Application for a Non-Material Amendment Following a Grant of Planning Permission

Construction of nine dwellings and associated works

20/02915/FU

HOUSE TYPE C - ELEVATIONS

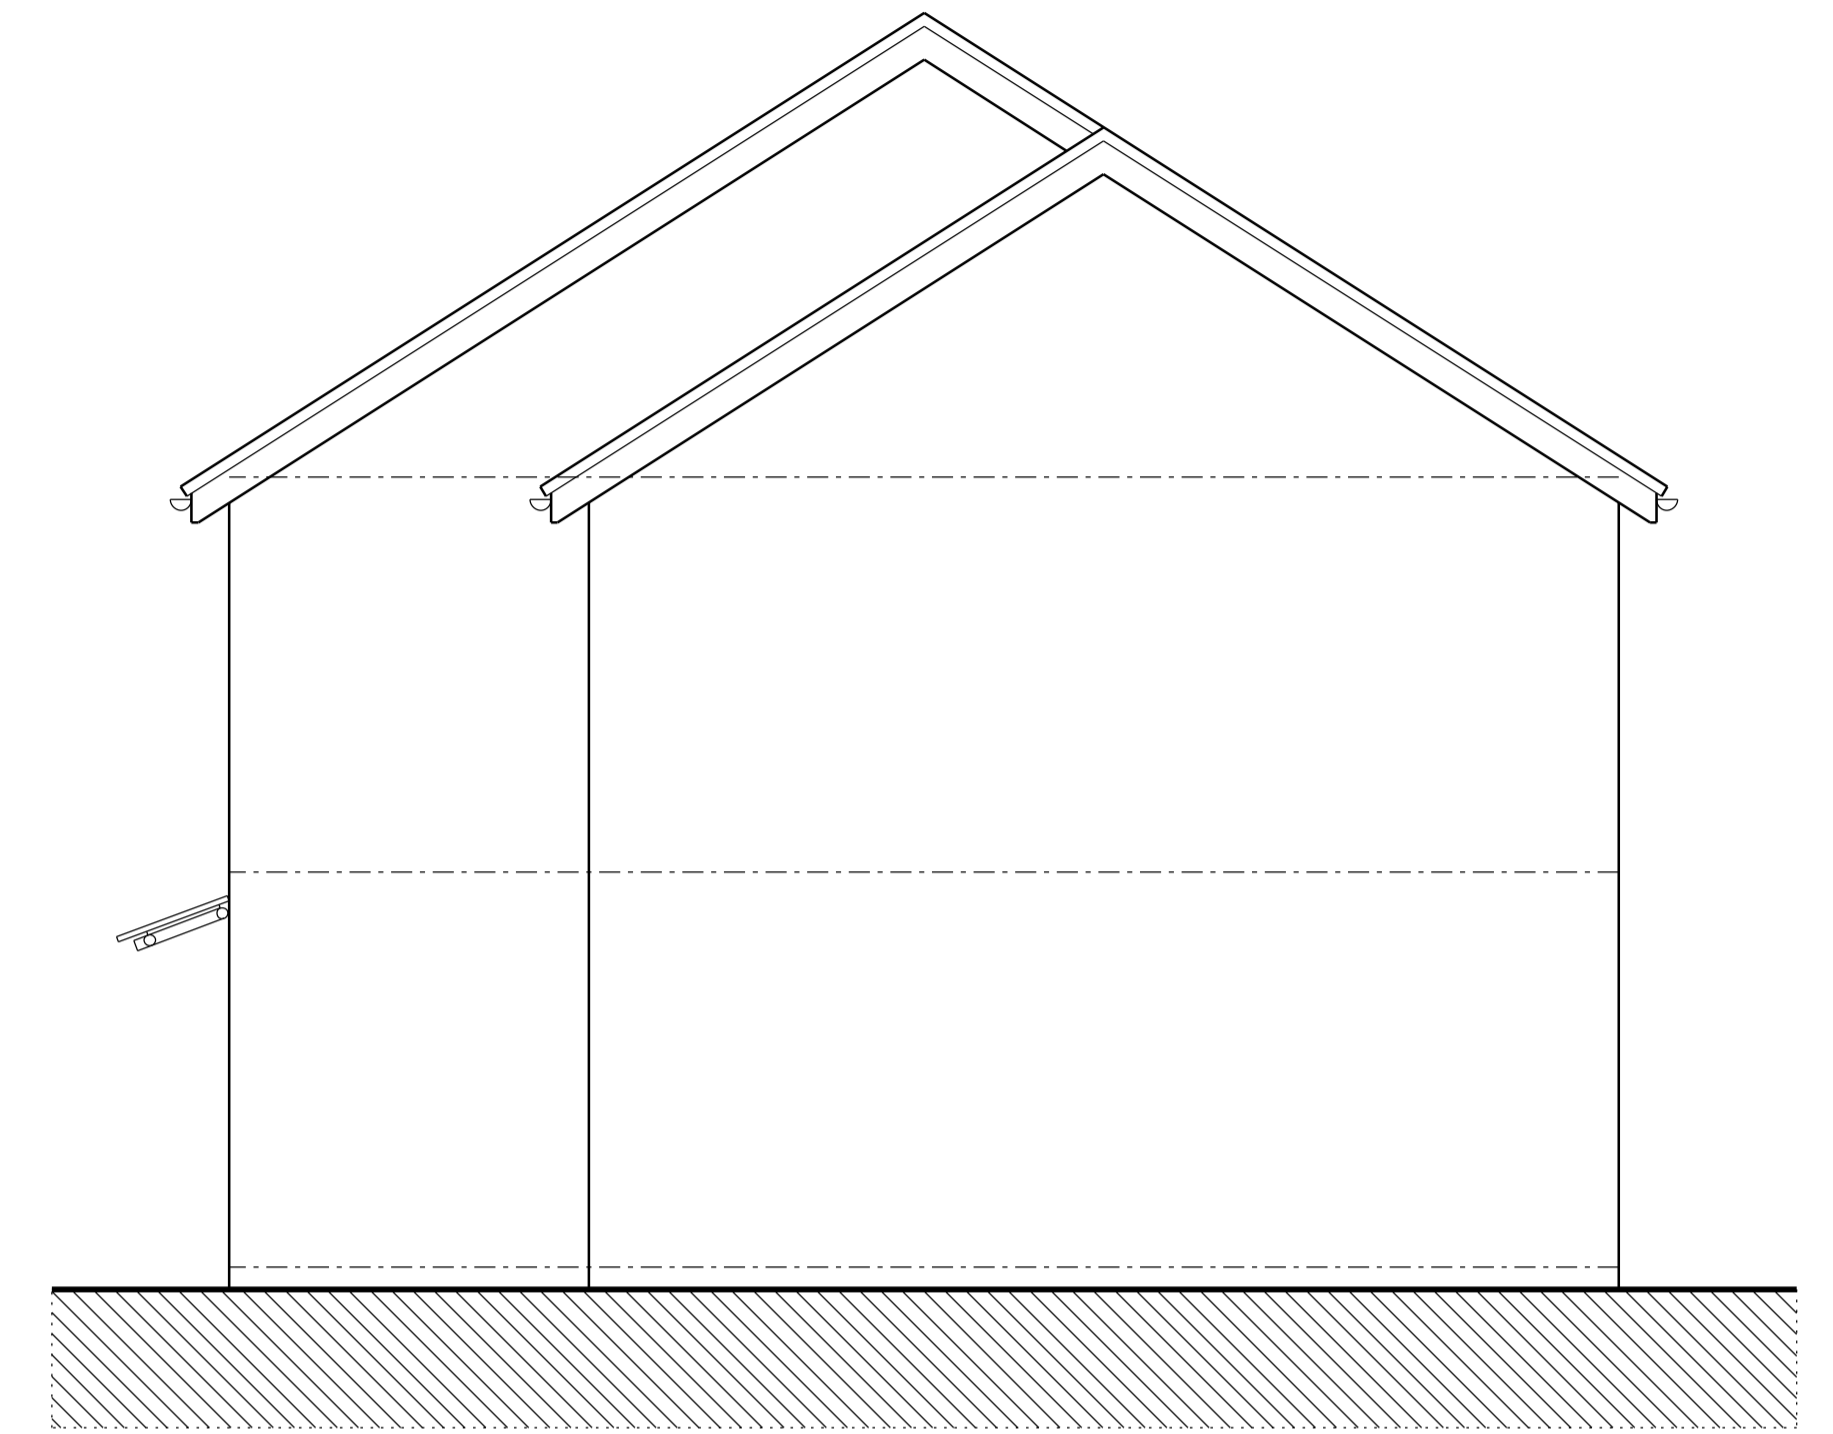
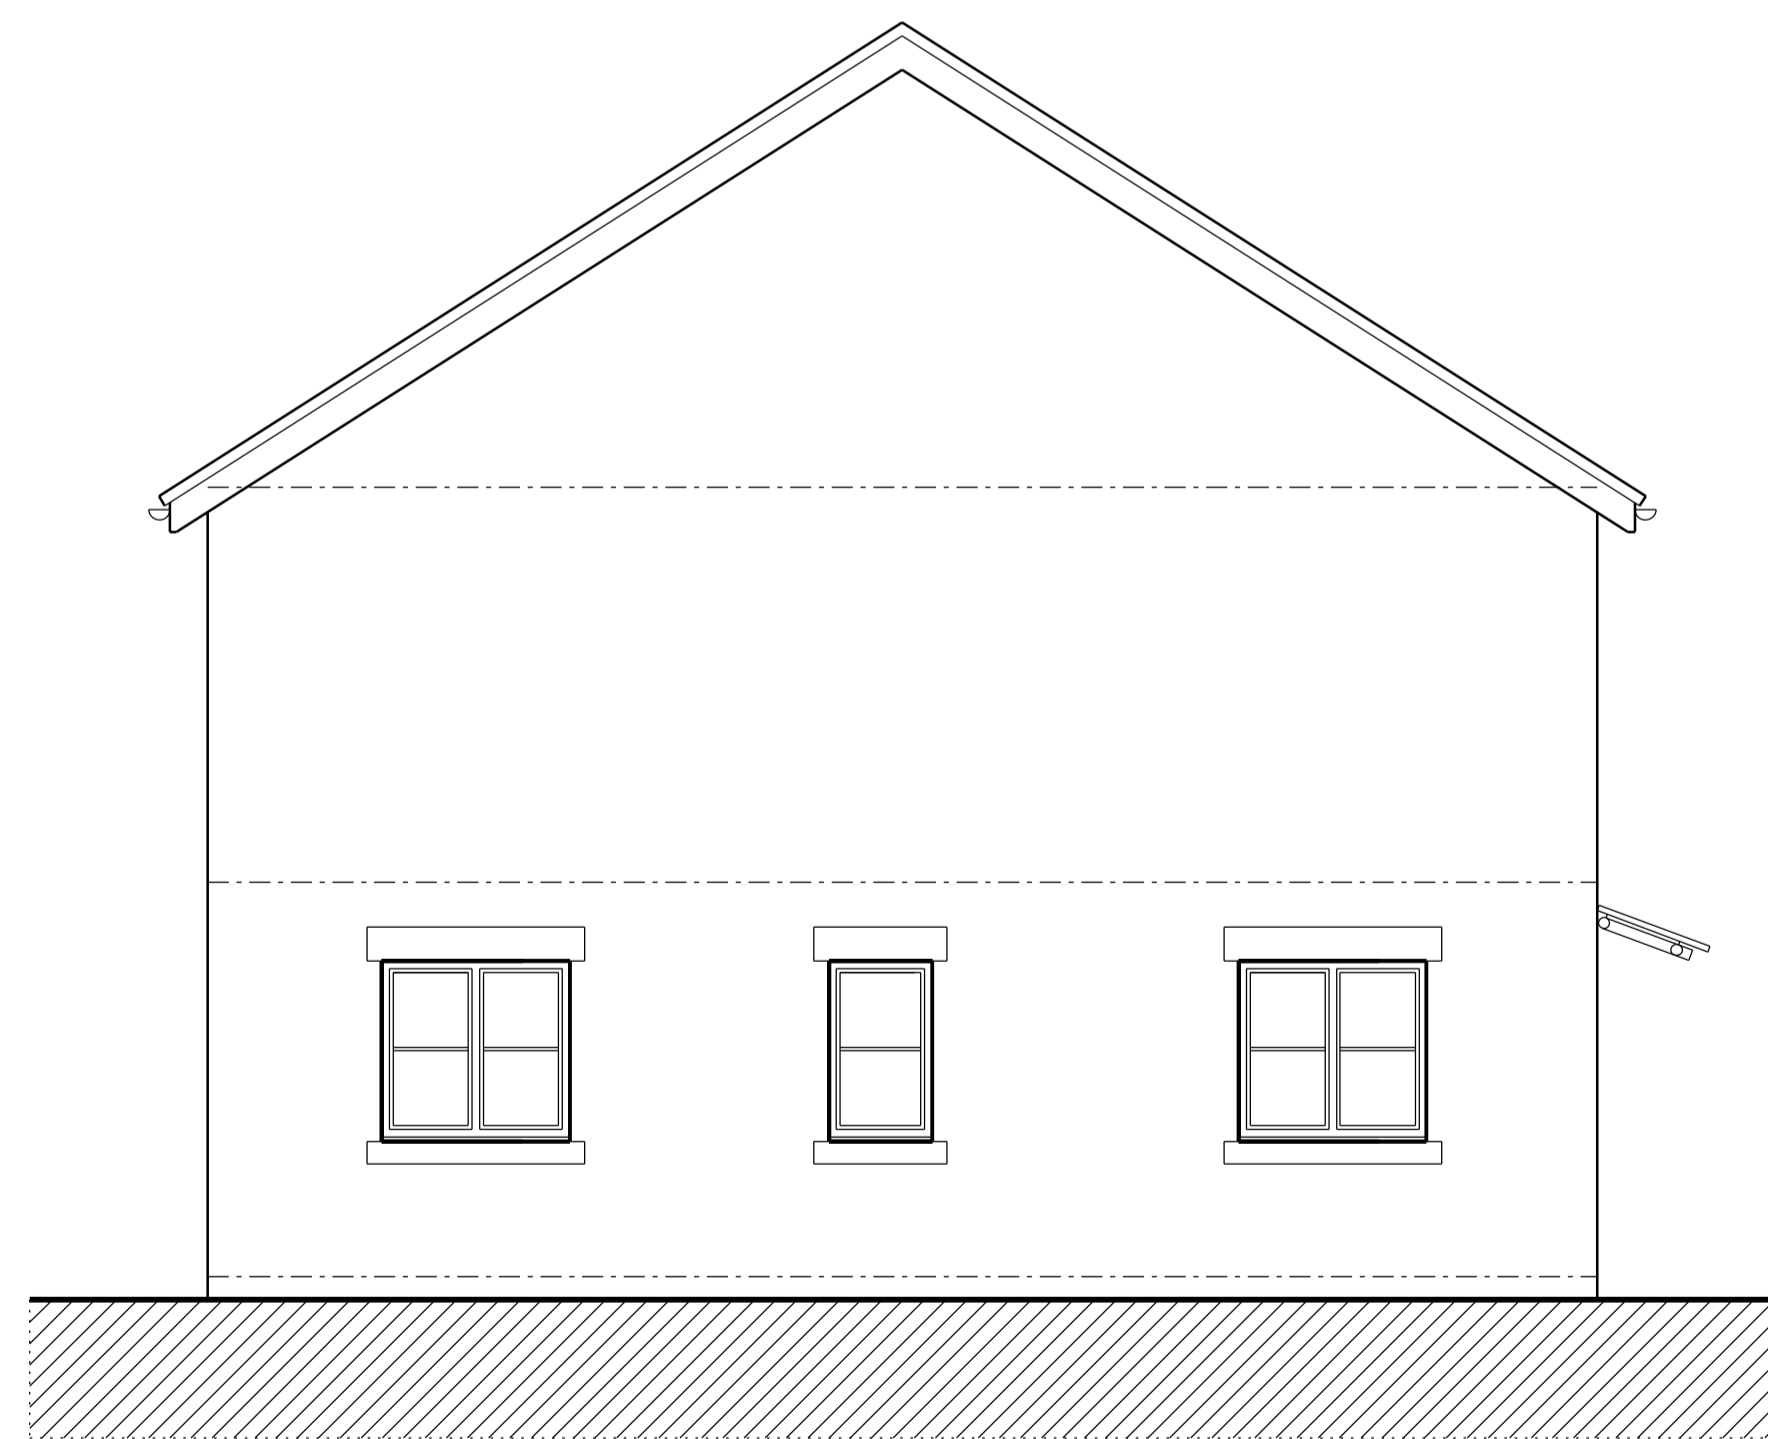
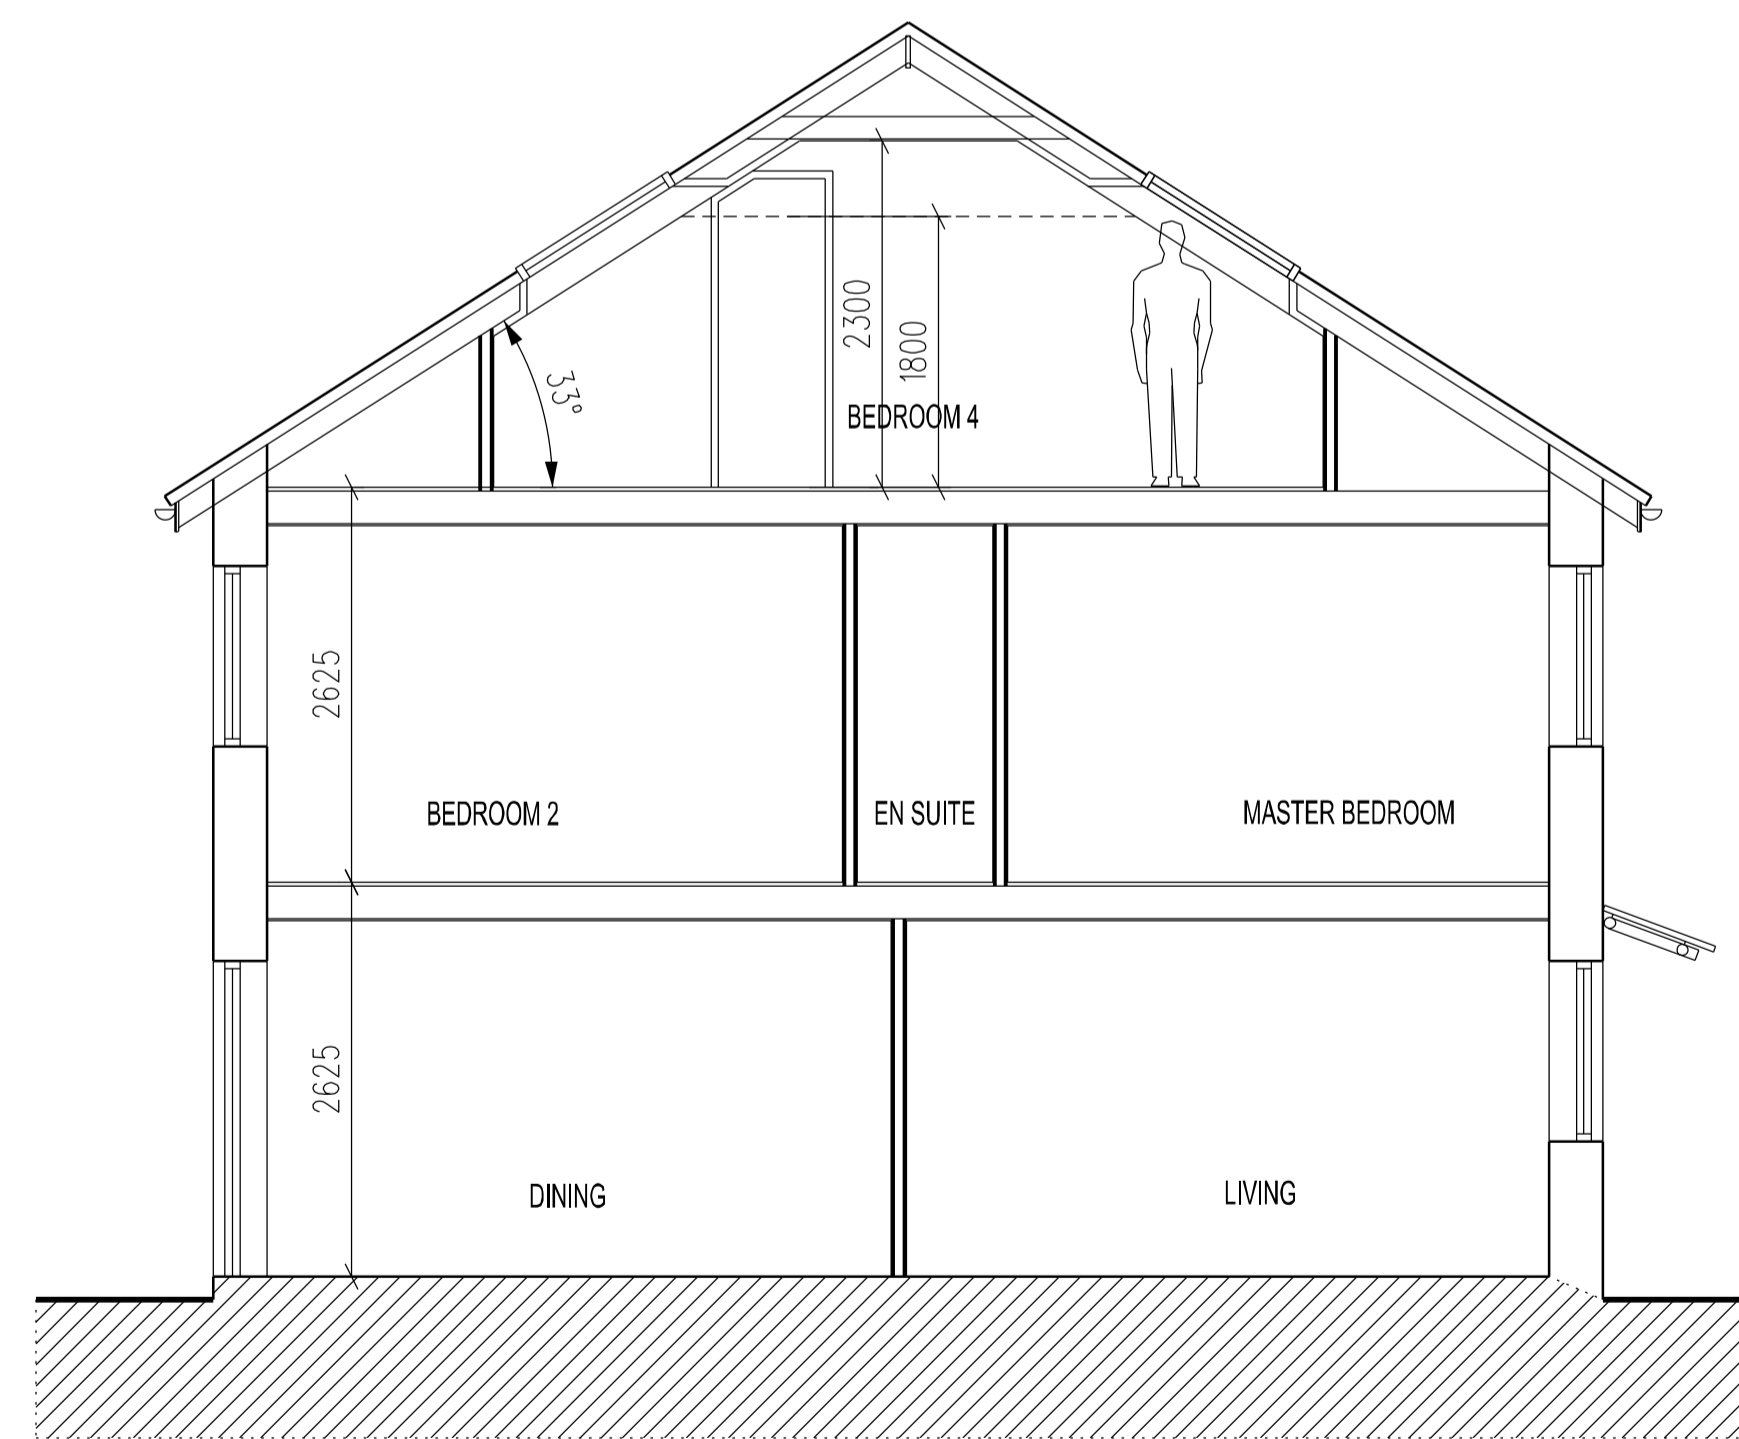
There has been an added ground floor garage to both house type C and house type F as well as an increase in floor area to both of these houses.

House Type C elevations Rev E replaced with Rev J
